To	Andrew Driver	Page	7
CC	Harry Quartermain		
Subject	Response to Sydney Coordination Officer Request For Information		
From	Martin Mallia		
File/Ref No.		Date	08-Jan-2019

AECOM Australia Pty Ltd (AECOM) was engaged by Hanson Construction Materials Pty Ltd (Hanson) to prepare a traffic impact assessment in support of the Environmental Impact Statement (EIS) prepared for the Glebe Island Aggregate Handling and Concrete Batching facility state significant development application (SSD 8544).

A number of key notes and action items were established during discussions between the SCO and the project team, which resulted in a request for information from SCO officers. This memo documents the key notes and action items arising from the consultation meeting of 3 August 2018, and outlines the project team responses.

GLEBE ISLAND 1 - Proposed Hanson Aggregate Facility & Concrete Batching Plant

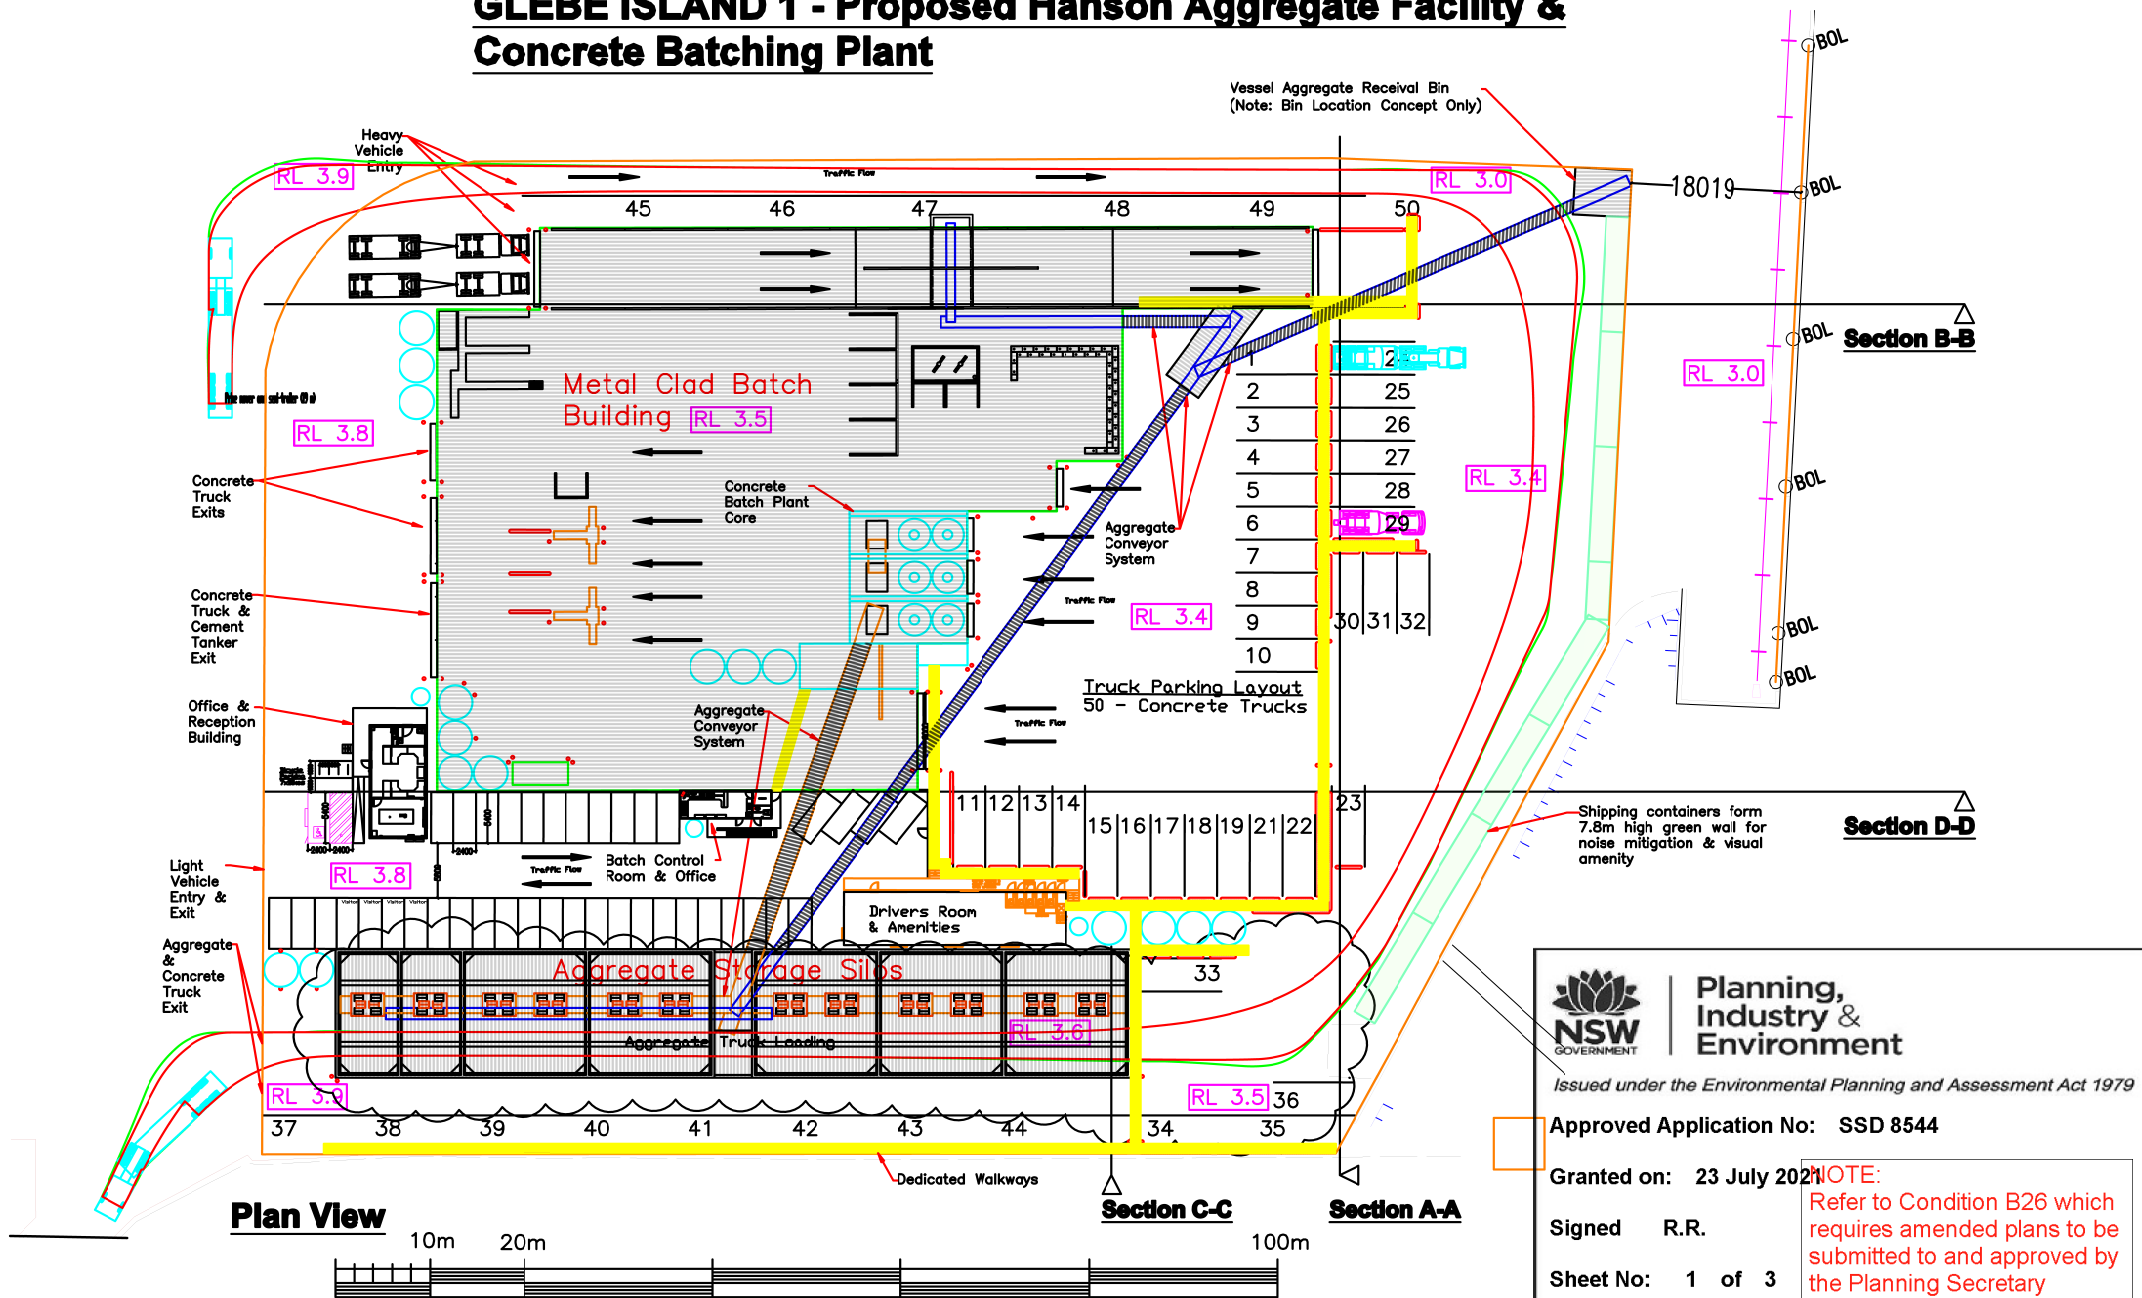
The provision of a parking space for each employee as envisaged would not support the take up of alternative modes and should be reviewed.

However, TfNSW have made a request to reduce the quantum of on-site parking to help encourage more sustainable methods of travel for staff to / from the site. Katherine McCray provided guidance for a parking rate that would be supported by TfNSW, which was to provide 0.7 parking spaces per employee. This rate was based on a review of journey to work mode share data for similar industries to the proposed development. Evidence of this advice is provided in **Appendix A**.

In response, Hanson has amended the site layout to reduce the number of staff parking spaces. With 67 members of staff employed at the site, the total quantum of parking spaces for staff on the site has now been reduced from 59 spaces to 35 spaces, with an additional four (4) spaces provided for visitors retained as per the traffic impact assessment. A green travel plan will be provided to all employees notifying them of the alternative transport options for them as discussed in the traffic impact assessment.

The amended site layout drawings are provided in **Appendix B**
